WEST SUSSEX COUNTY COUNCIL CONSULTATION

TO:	Arun District Council FAO: Simon Davis
FROM:	WSCC - Highways Authority: Tim Townsend
DATE:	26th February 2021
LOCATION:	Land At Wings Nursery Lidsey Road Woodgate PO20 3SU
SUBJECT:	AL/20/21/PL Demolition of Wings House & erection of 71 No. replacement dwellings (70 net new dwellings), access arrangements, sustainable drainage measures, public open space, landscaping & all other associated works (resubmission following AL/46/20/PL). This application is a Departure from the Development Plan.
DATE OF SITE VISIT:	n/a (visited as part of the assessment undertaken for previous proposals AL/117/17/OUT, AL/32/19/OUT and AL/46/20/PL).
RECOMMENDATION:	More Information Required
S106 CONTRIBUTION TOTAL:	TBA

This is the WSCC Highways (CHA) response to the above planning application for demolition of Wings House & erection of 71 No. replacement dwellings (70 net new dwellings), access arrangements, sustainable drainage measures, public open space, landscaping & all other associated works (resubmission following AL/46/20/PL).

Drawing No.
2019-6115-002

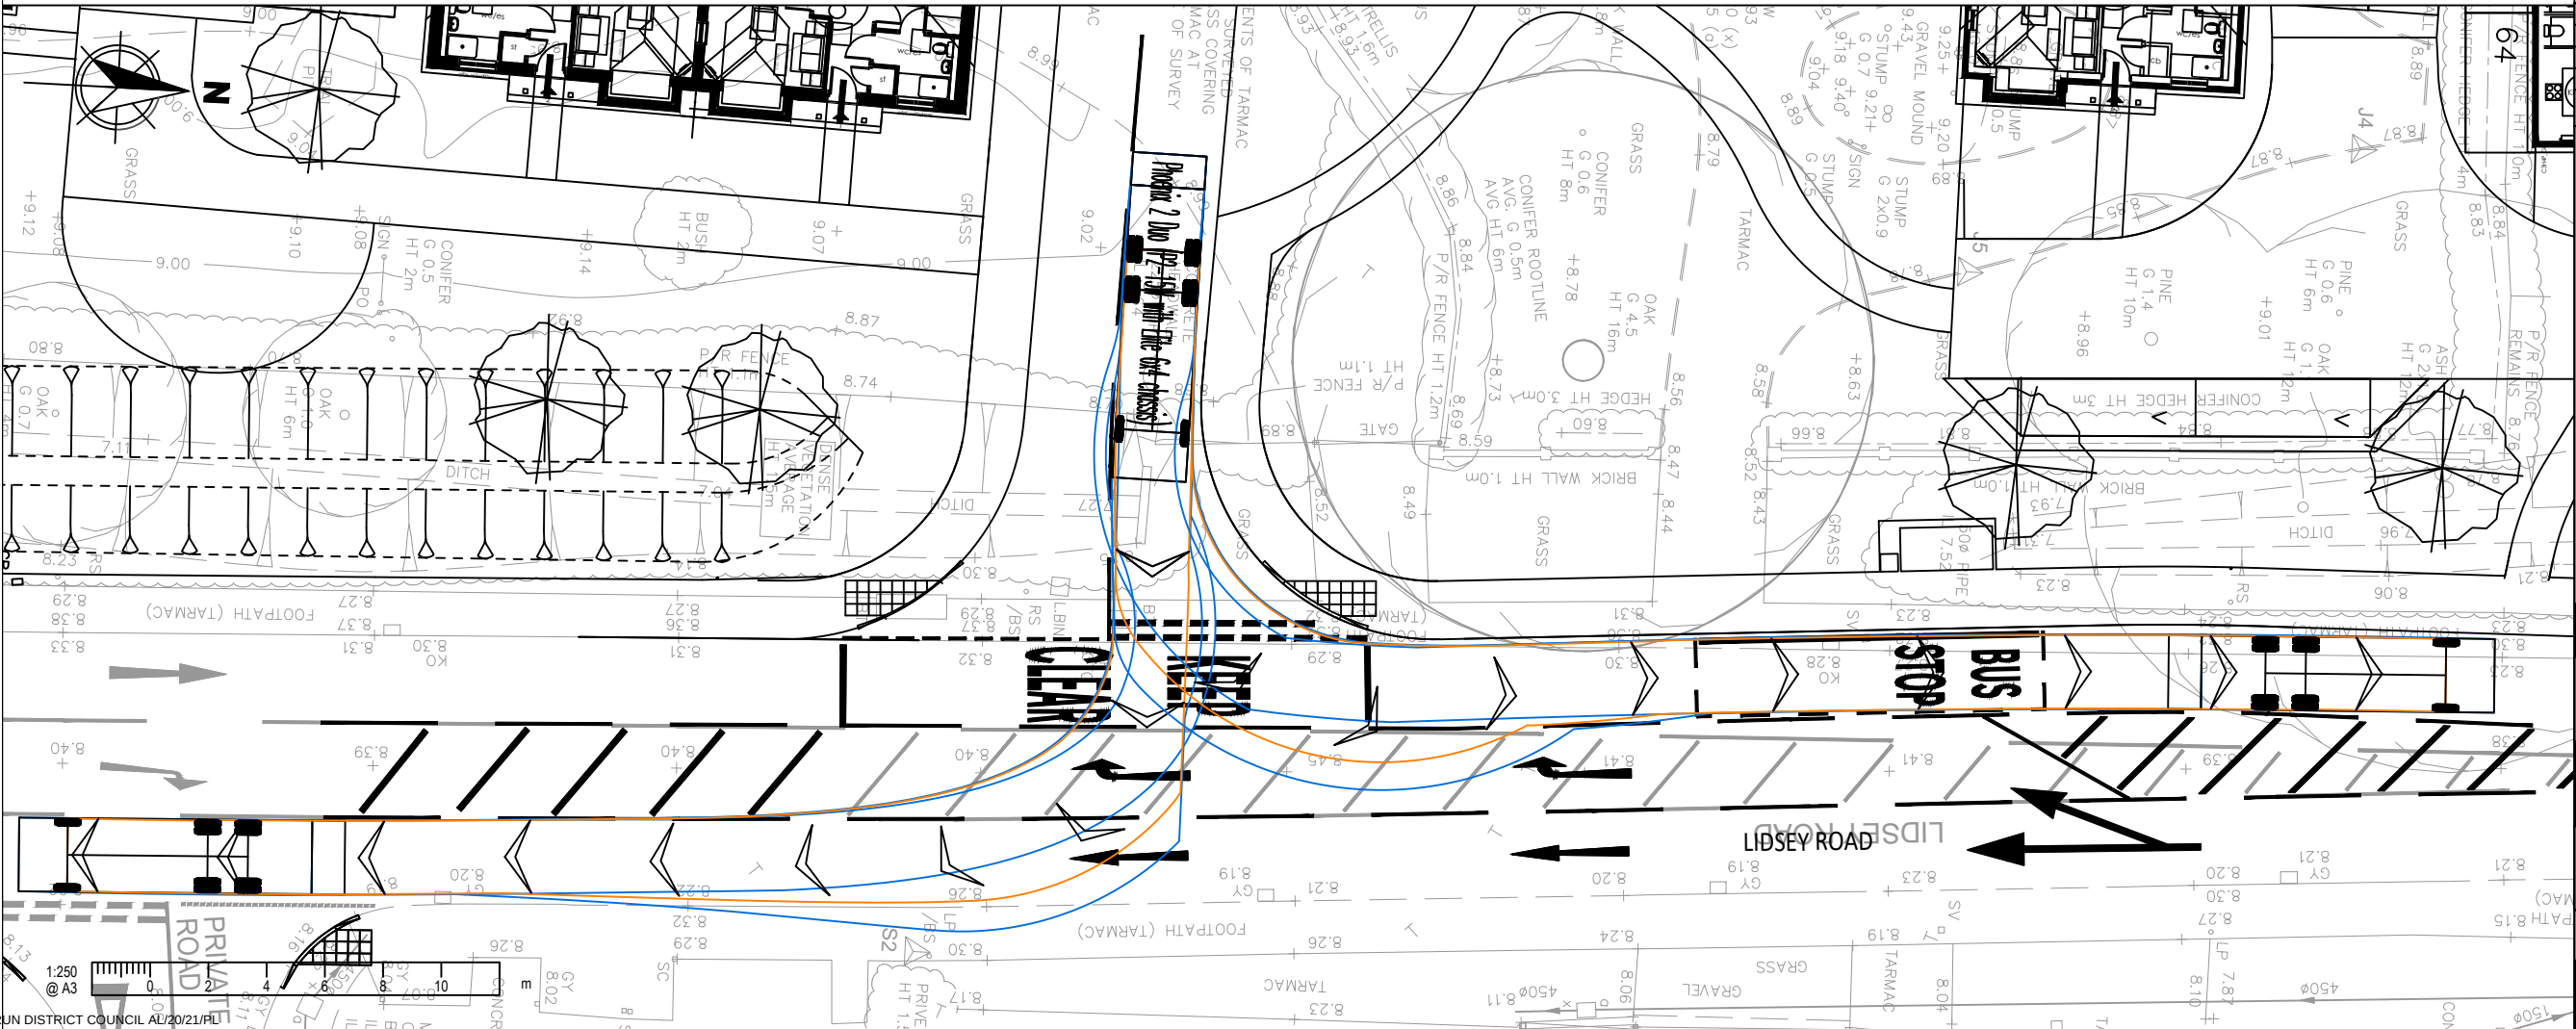
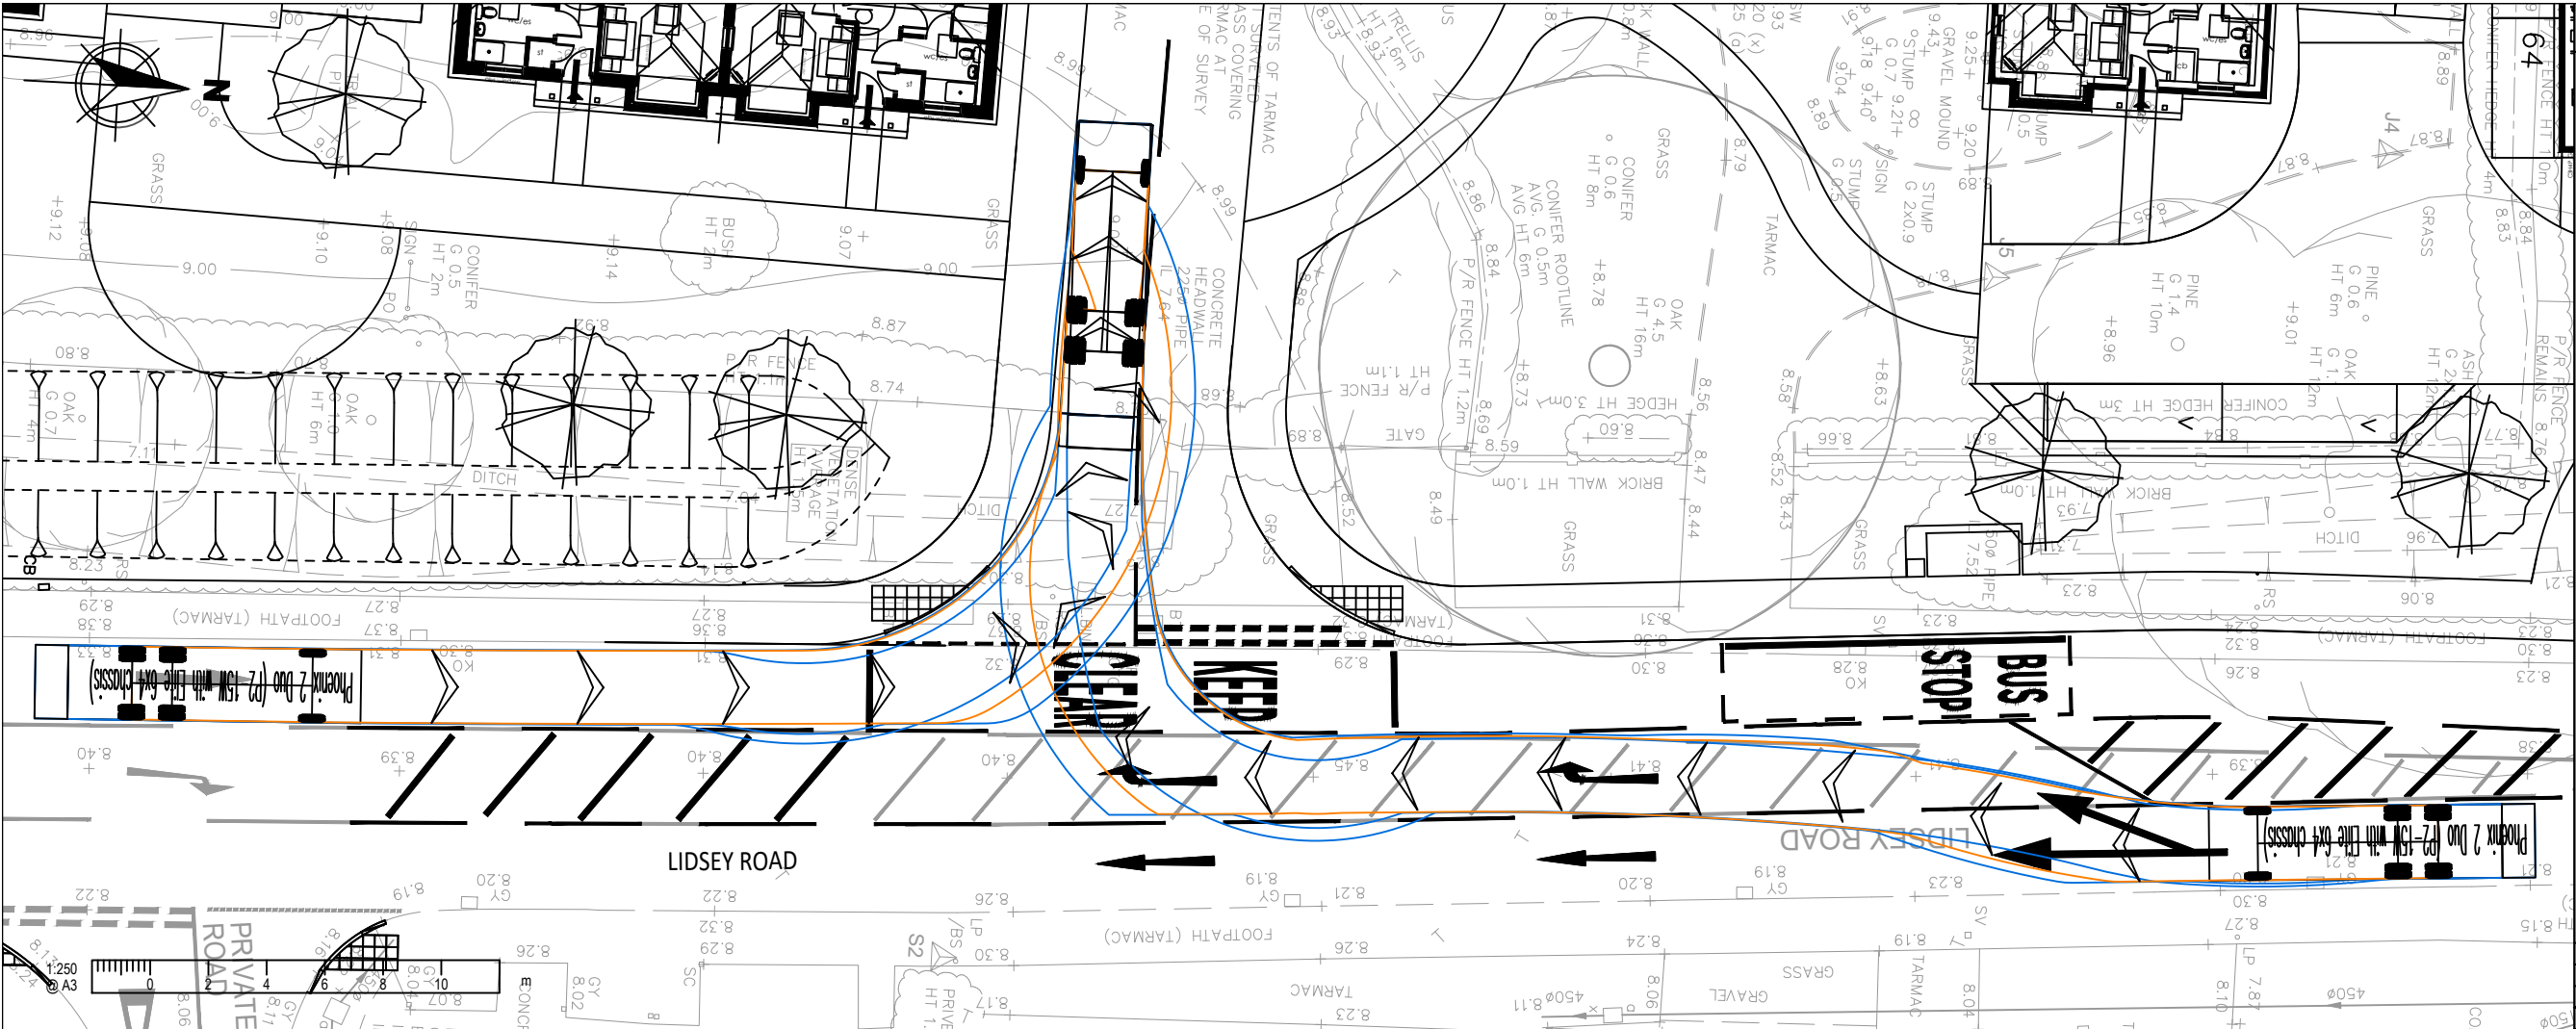
final design to the Highway Authority's satisfaction (covers both access points and associated works to the public highway). However and specifically with regard to the secondary access, the applicant does need to demonstrate that the turning area for a refuse vehicle is large enough (a tracking diagram for a fire appliance has already been provided). A plan and tracking information to demonstrate the latter is required.

- A tracking diagram should be provided showing a refuse vehicle turning in the turning area in the private 'secondary driveway' adjacent to plots 63 and 64.
- A tracking diagram for a selection of vehicles should be provided showing their path around the proposed relocated north-bound bus stop marking on the A29. As shown, there appears to be a potential conflict point where vehicles attempting to overtake a stationary bus would enter part of the right hand turning lane which could result in collisions. As a result, the bus cage and bus stop might need moving. This element of the re-design should also be passed to the Road Safety Audit Team to review and comment on.

- Turning for a refuse vehicle is not demonstrated adjacent to plots 63 and 64. Furthermore, another area of concern is the width of the access road serving plots 5-10. This appears to be 4.1m wide which is easily blocked if a vehicle were to park on it. This should be widened to a minimum of 4.8m wide.
- Given the lack of service margins and location of some of the parking immediately adjacent to parts of the internal roadways, the layout would not be suitable for adoption under S38 in its current guise.
- Parts of the layout give a 'mixed message' with regard to user priority etc. particularly where only a single footway is provided and then terminates before what appears to be a shared-surface area. This needs to be shown better-defined (one example being by plots 38 and 48). A coloured site plan should be

1. Tracking diagram for a refuse vehicle adjacent to plots 63 and 64.
2. Tracking for a selection of vehicles travelling north-bounds negotiating a stationary bus in the re-located bus stop north of the primary access.

Parking Strategy Diagram

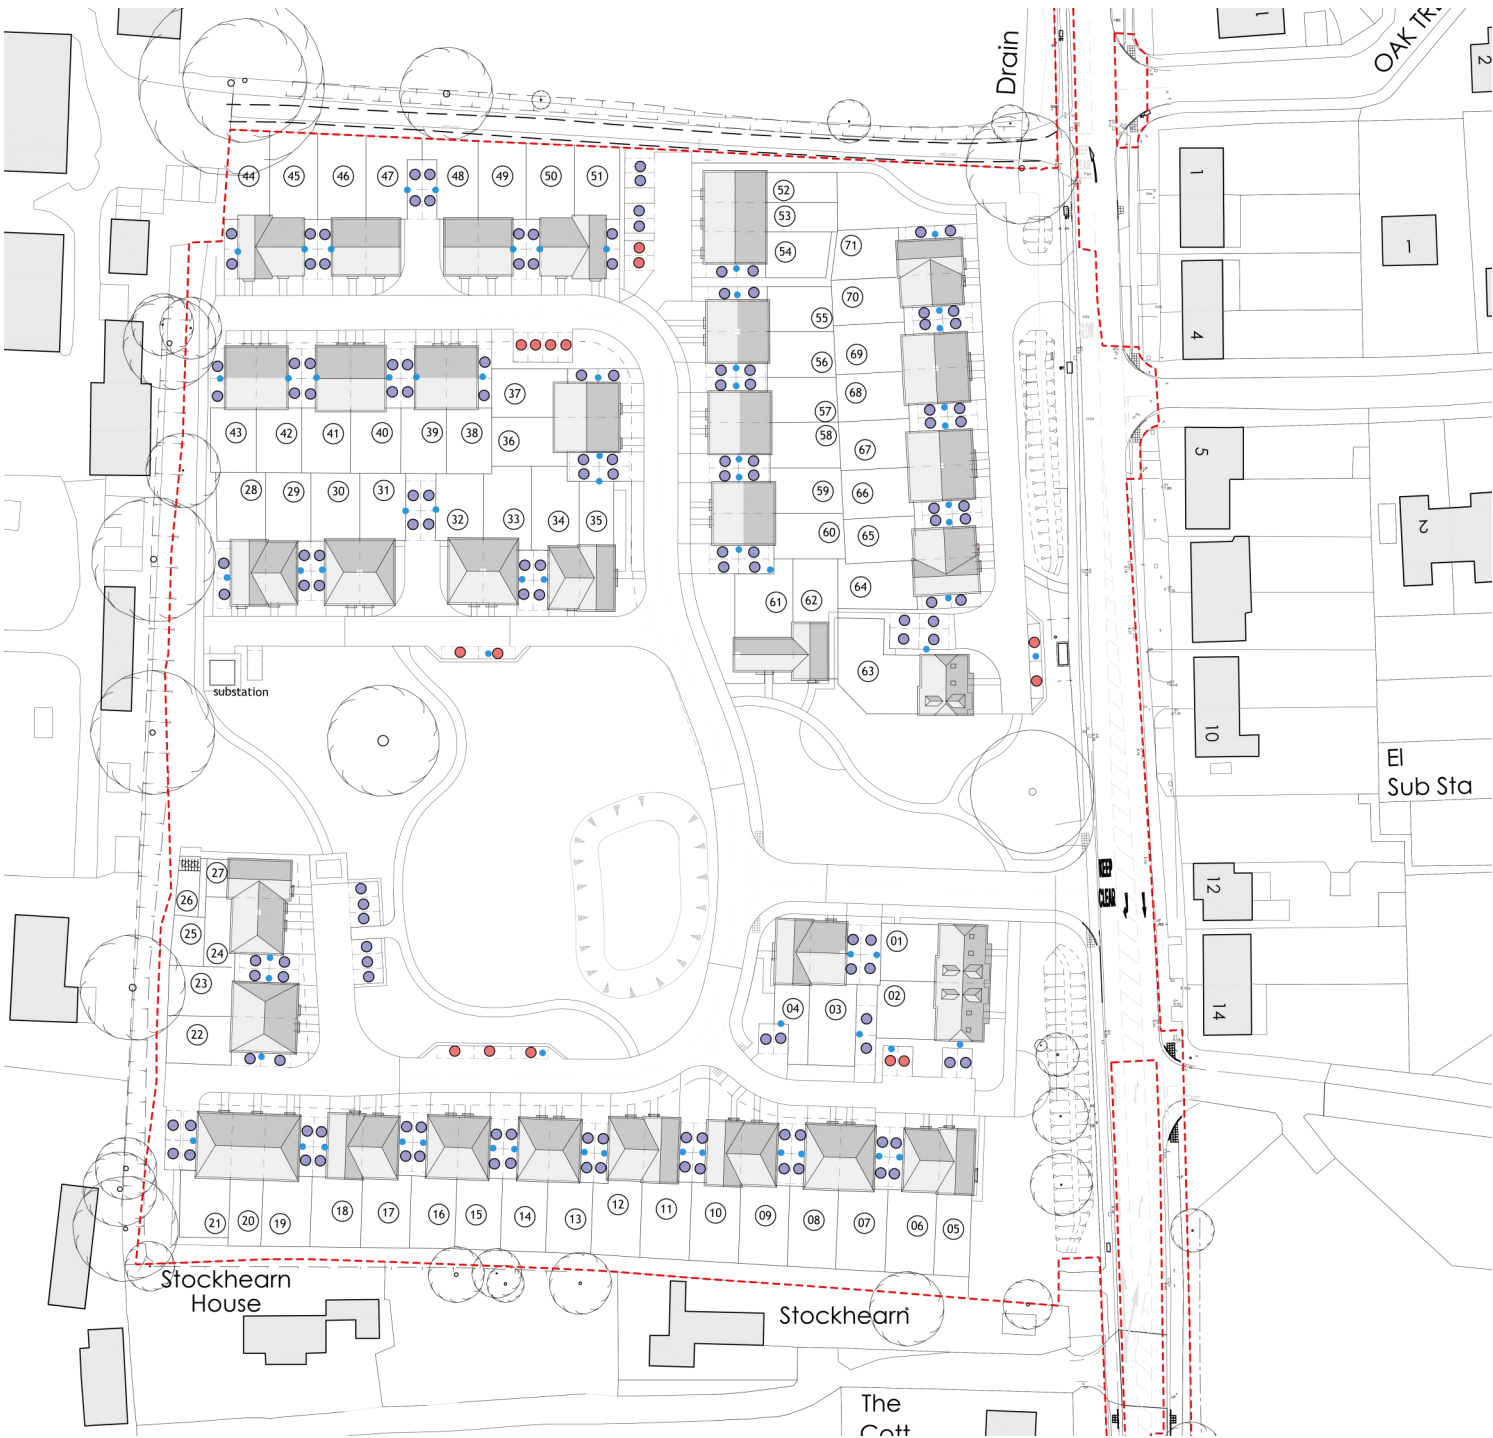
- A large number of the parking spaces appear to be narrow with a number in confined spaces. This will make them difficult to use and un-attractive to users, resulting in parking on-street. As such, all parking design should be re-visited with regard to sizing/dimensions. Single spaces with no obstructions either-side – should measure 2.4m wide and 5.5m long. Where driveways are 'shared' (so household spaces next to one-another), driveways should be 6.0m wide. If spaces are to be bounded by obstructions (e.g. walls, fences etc.), single spaces should be widened to at least 3.5 wide and dual spaces to 7.0m wide. Where garages are to be used, these should have internal measurements of 6m x 3m. Access to the parking spaces for plot 43 is very restricted. Enlarging the end of the adjacent access road would assist with improving this.
